Response to Planning application from Hertfordshire County Council (T and CP GDP Order 2015)

District ref: 6/2023/2182/COND
HCC ref: WH/18817/2023
HCC received: 6 November 2023
Area manager: Matthew Armstrong
Case officer: Matthew Armstrong

Land to the north east of King George V Playing Fields Northaw Road East Cuffley EN6 4RD

Submission of details pursuant to condition number 14 (Theobalds Road Route) on planning permission S6/2015/1342/PP

DRAWING TITLE
**S278 THEOBALD'S ROAD -
WORKS PLAN**

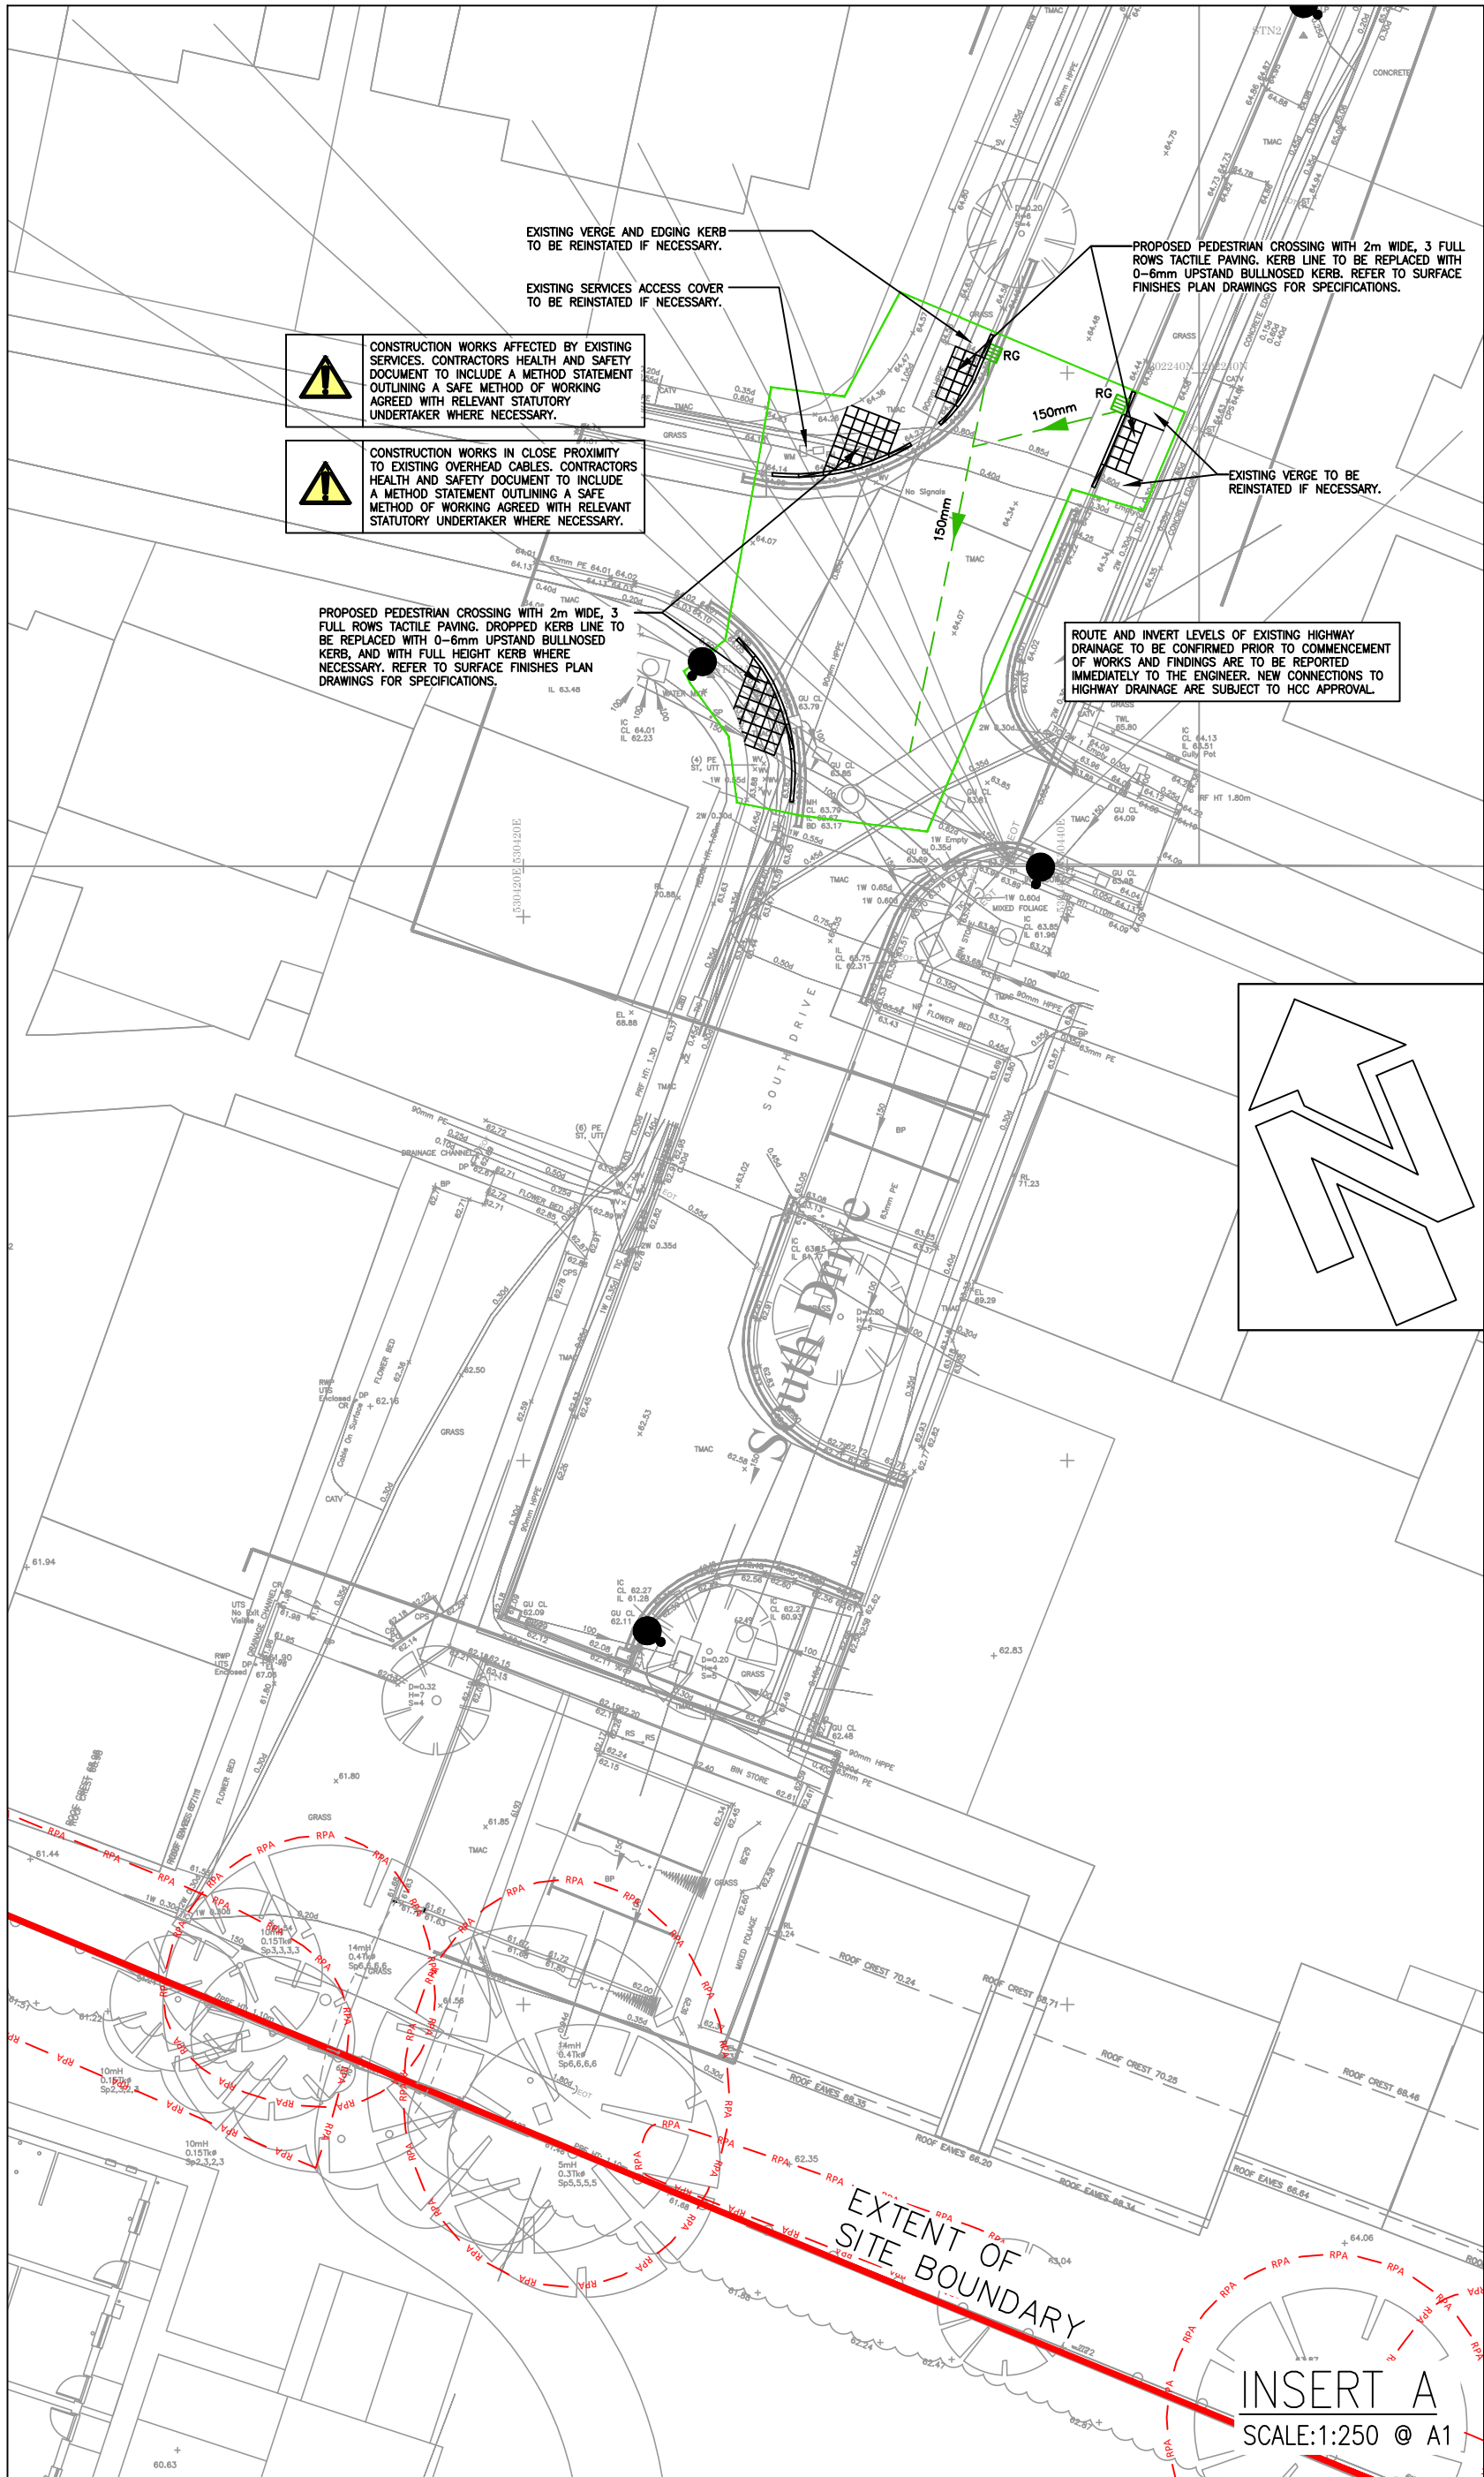
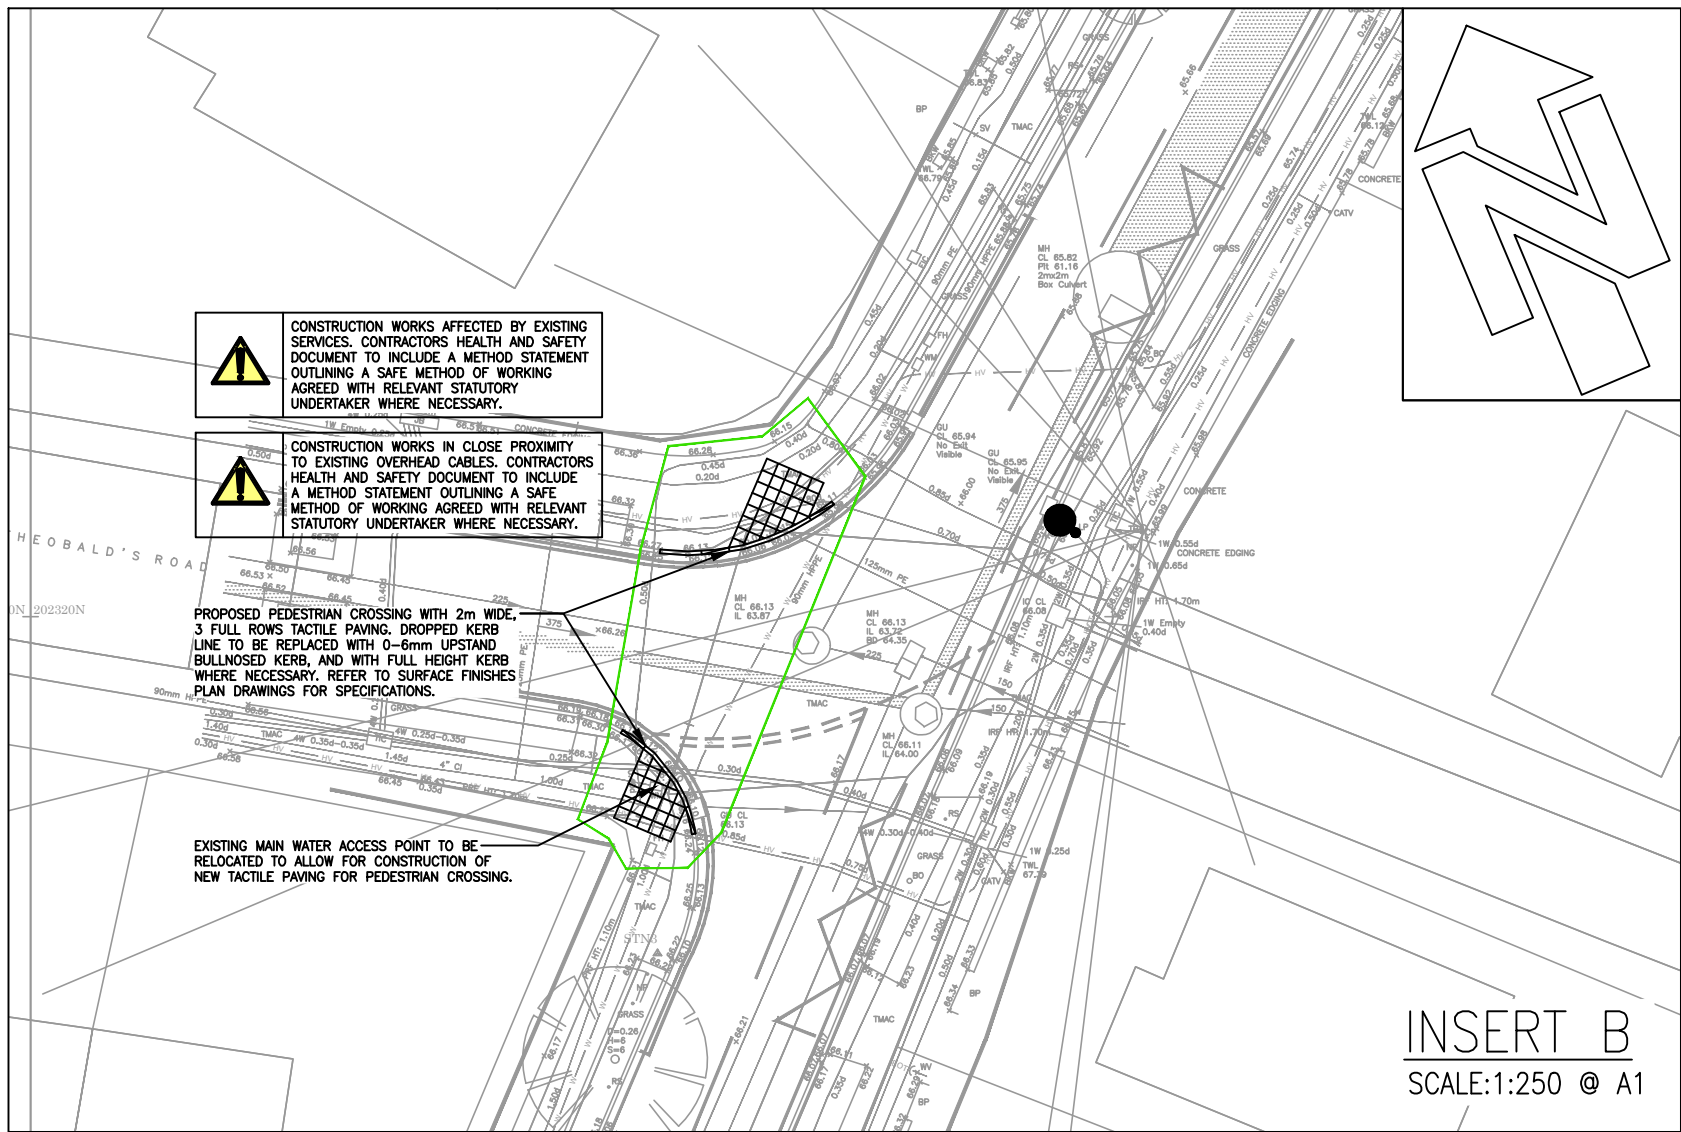
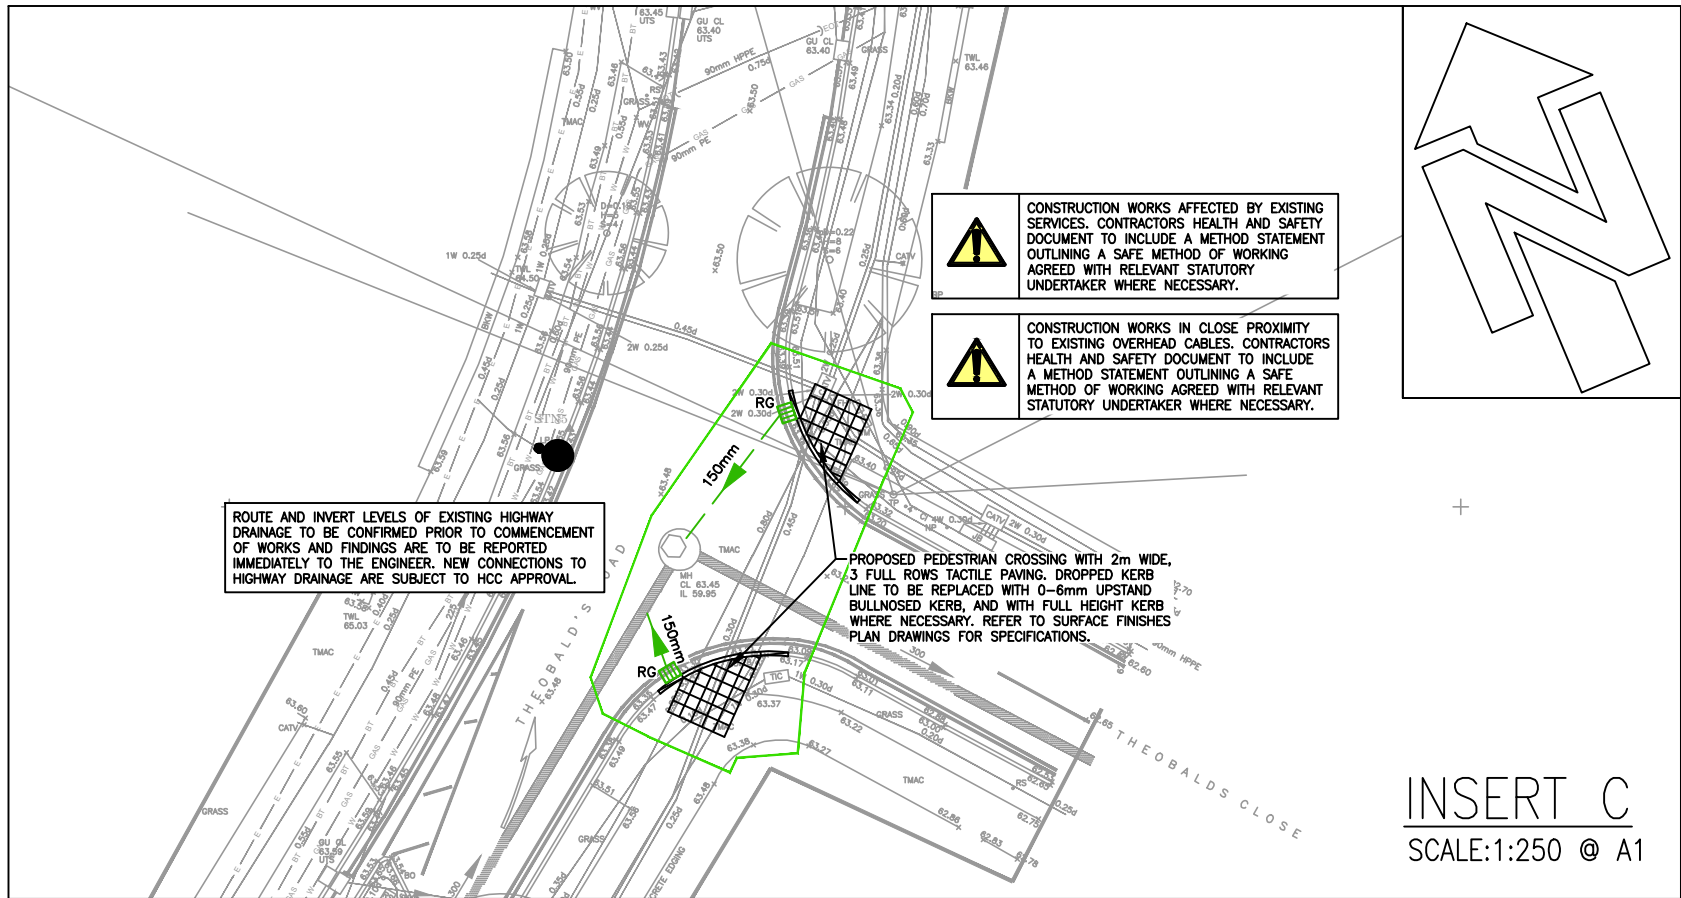
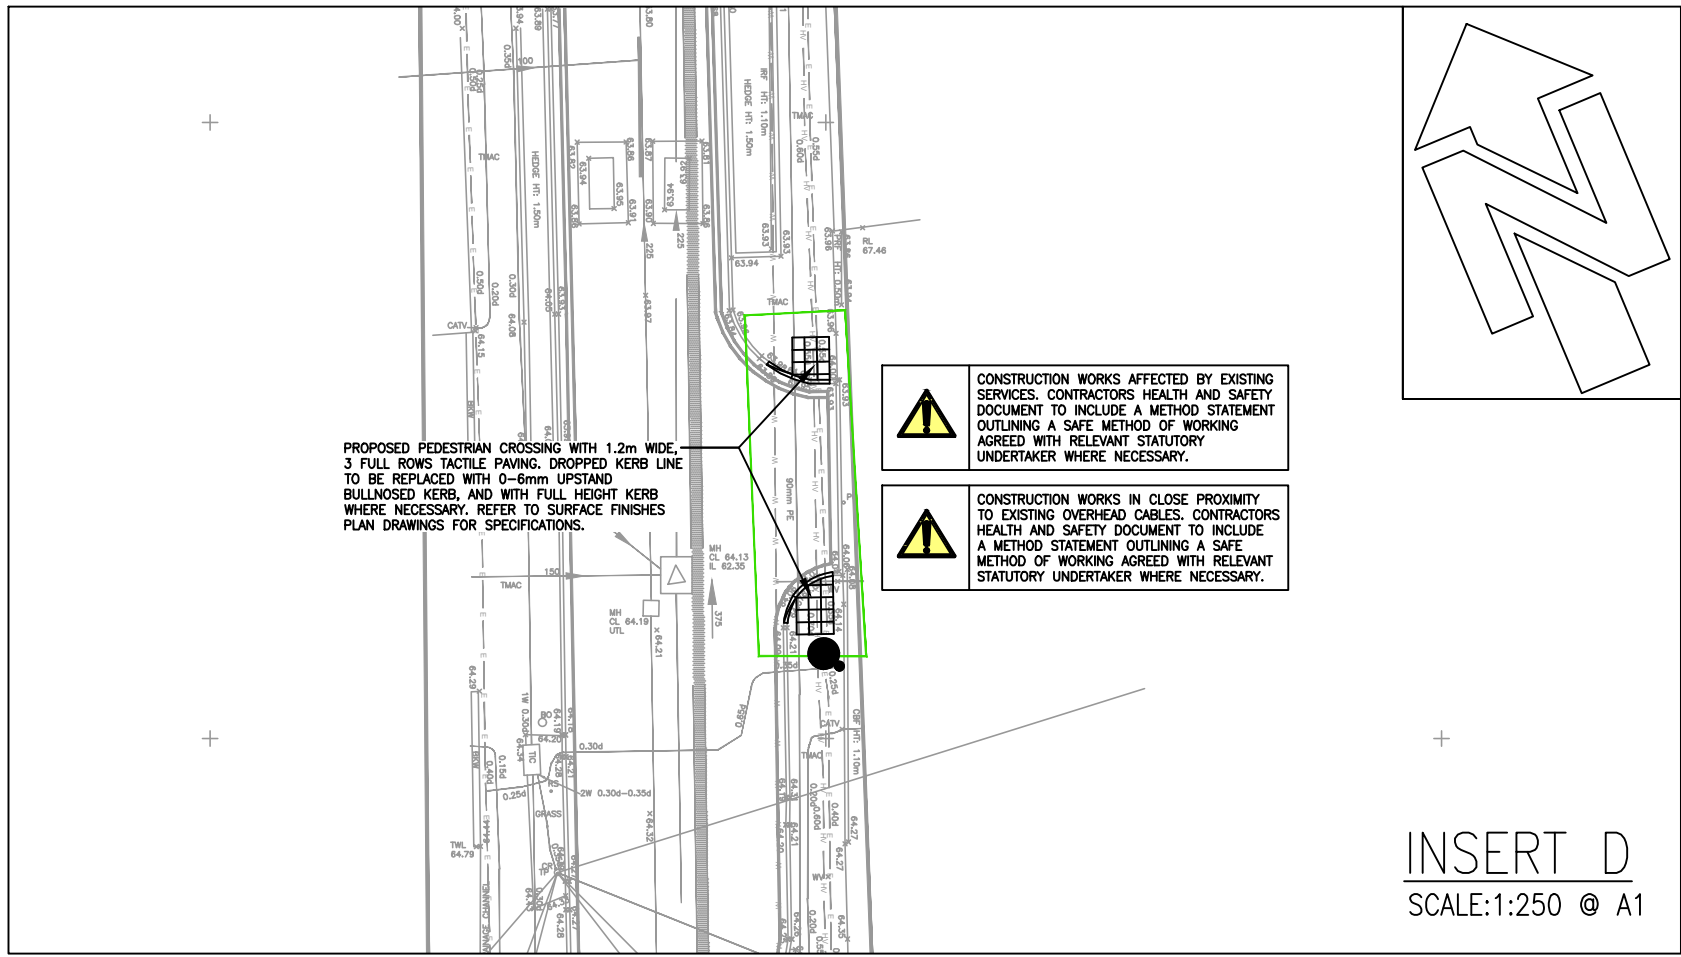
COMMENTS: The condition requires submission and approval of detailed engineering drawings (i.e. approved s278 plans). For this planning application, the applicant has submitted earlier s278 plans which have not received Technical Approval. As part of the stage 2 Road Safety Audit / s278 process, it was identified that there is a need for these plans to be revised, albeit only slightly. Once the latest s278 plans (with Technical Approval) are submitted as part of this discharge of condition application, the first part of the condition can be discharged. As the works are not in place on the ground, it is premature to discharge the second part of the condition.
